Application No: Y/150/21/HH
Site Address: 15 Kings Close Yapton BN18 0EX
Description of works: Detached single storey home office/garden building in rear garden.

Thank you for your internet representation made on 19th November 2021 which has been recorded as an objection with the comments as follows:

South View

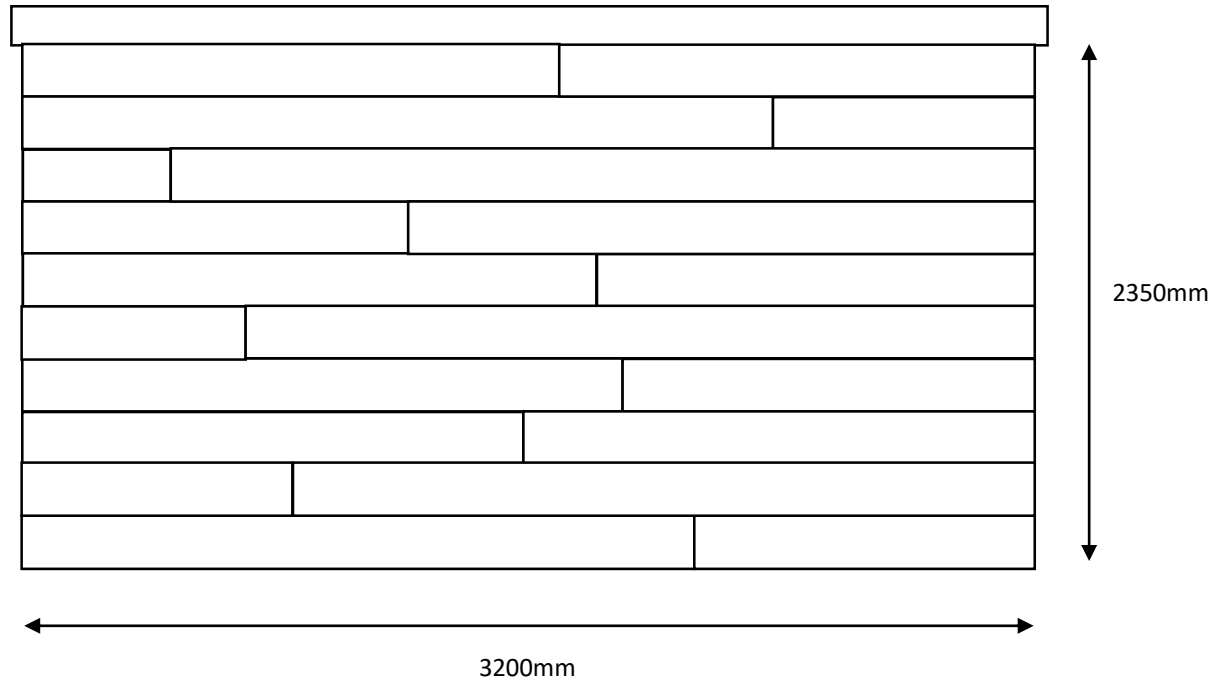
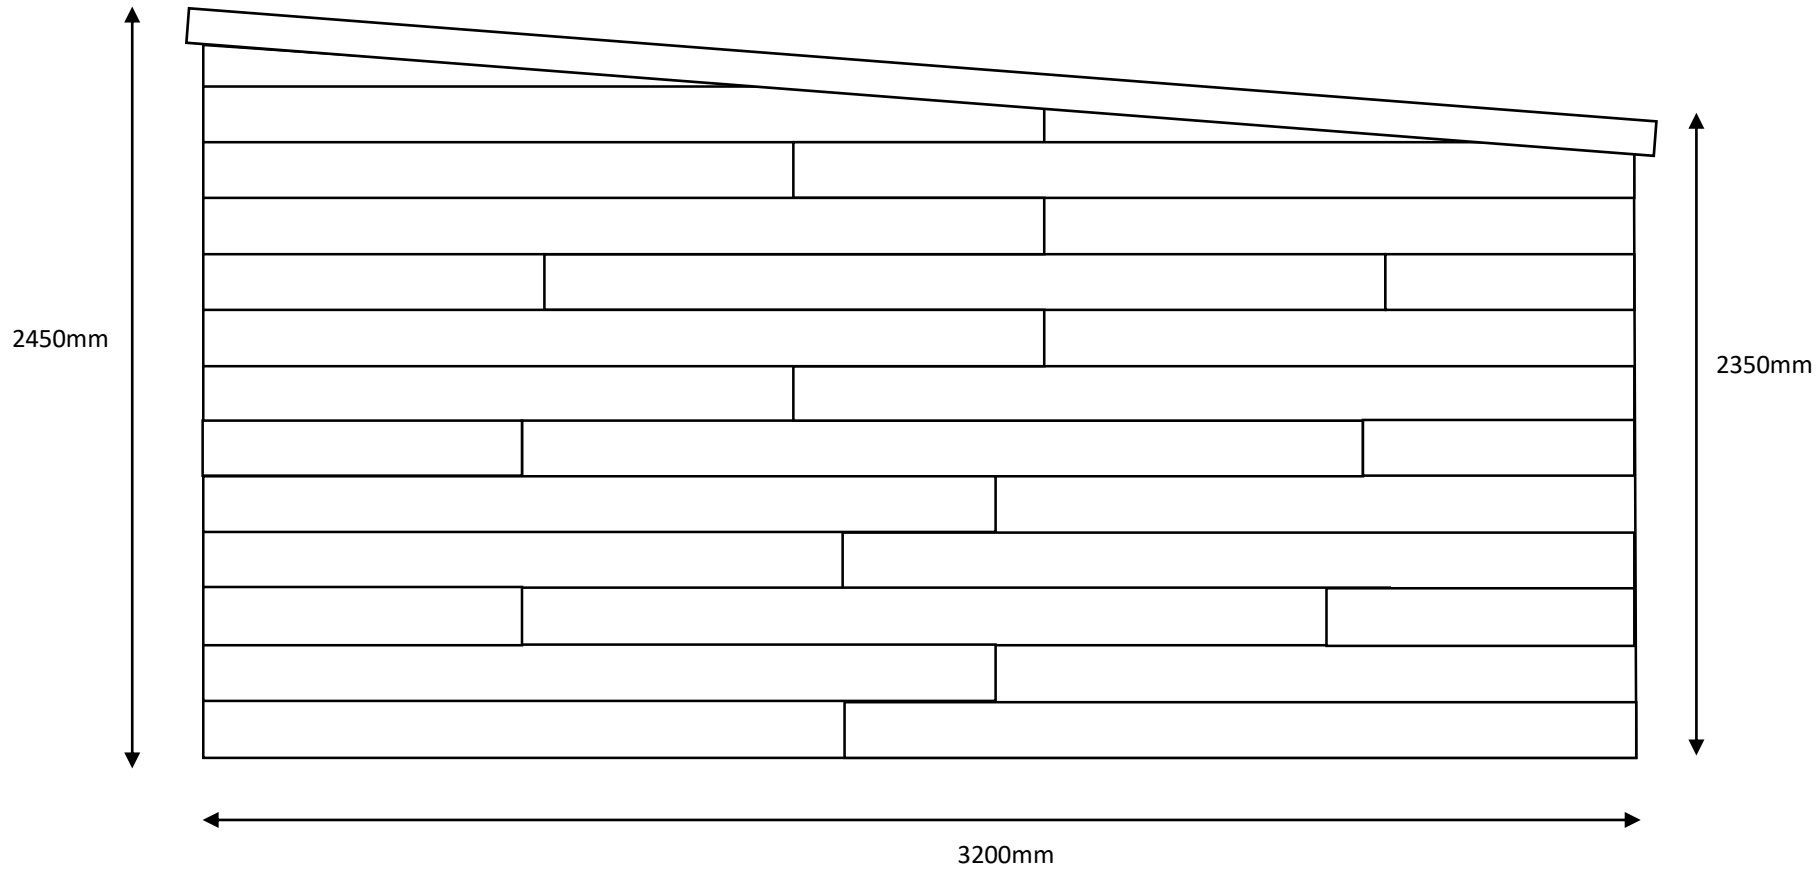
On a point of detail how is any cladding to be applied to the elevation immediately adjacent to the existing fence?

Garden Layout

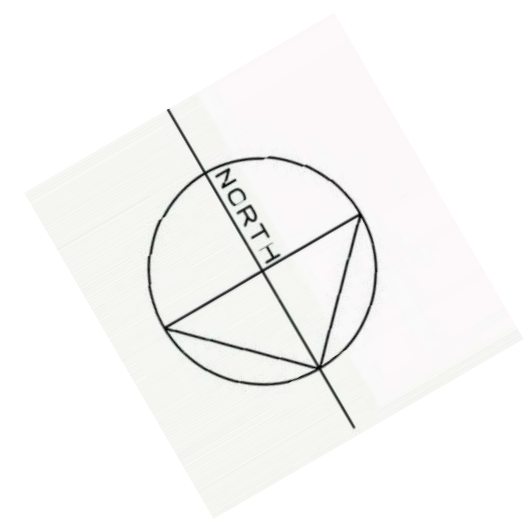
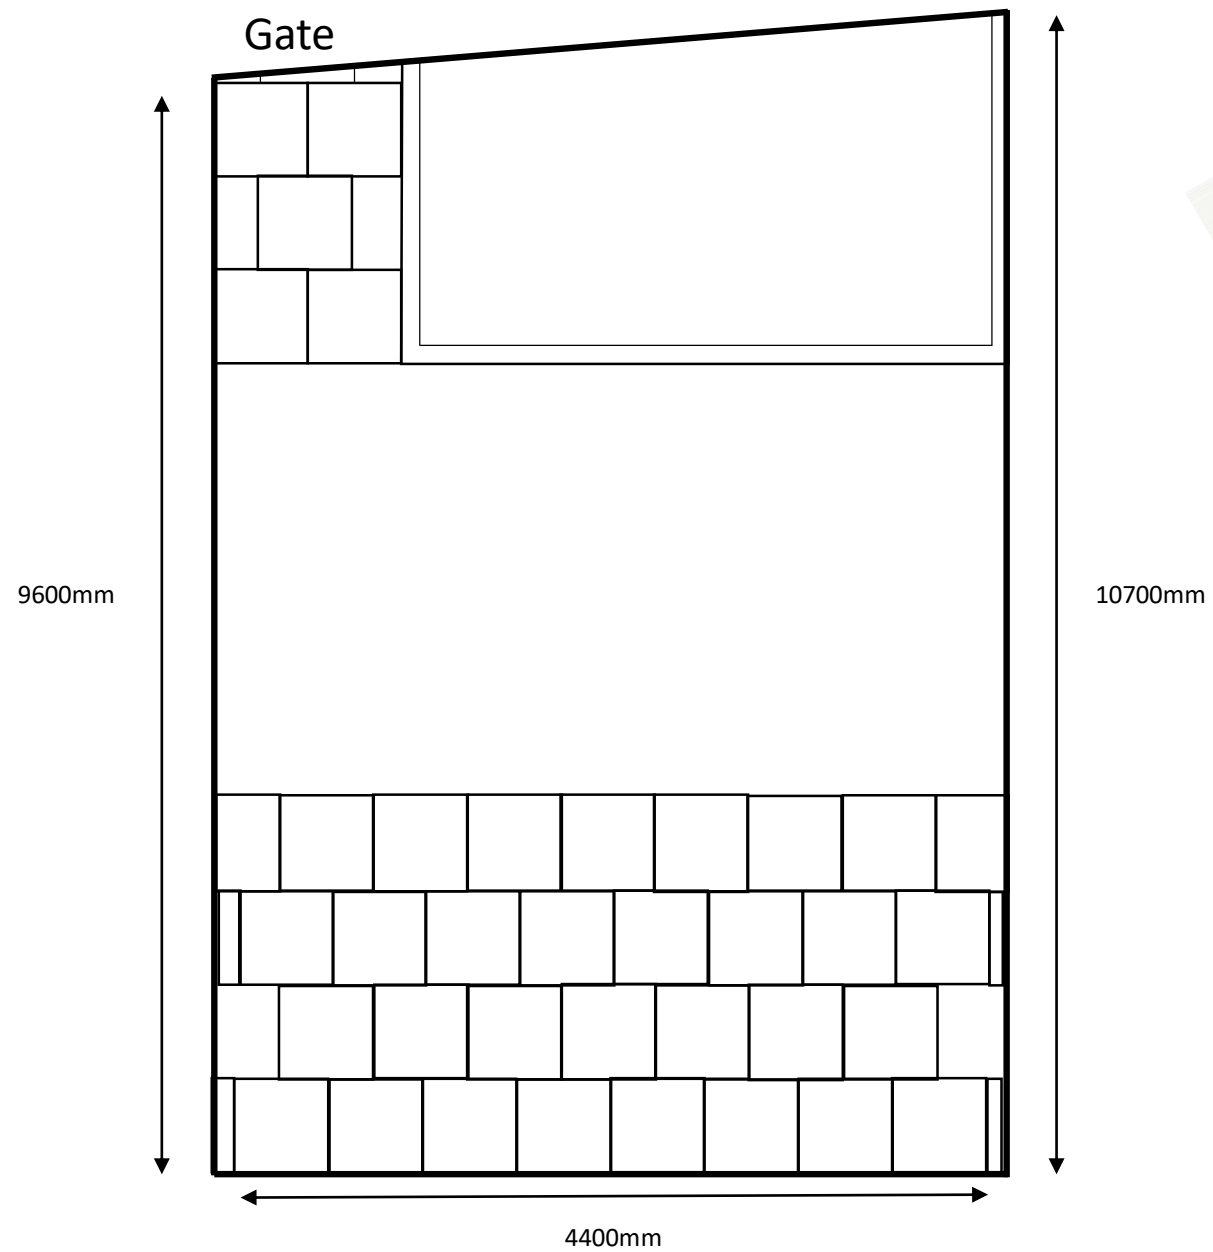
The gardens are small and the sheds provided are proportionate, more than adequate for two bikes, mower, gardening equipment and storage.

With limited plot sizes, so large an outbuilding has a material effect on our outlook, in addition to which, if this application were allowed, is a precedent then set for similar structures in adjacent, small gardens, the combined effect providing a 'garage compound' in appearance terms?
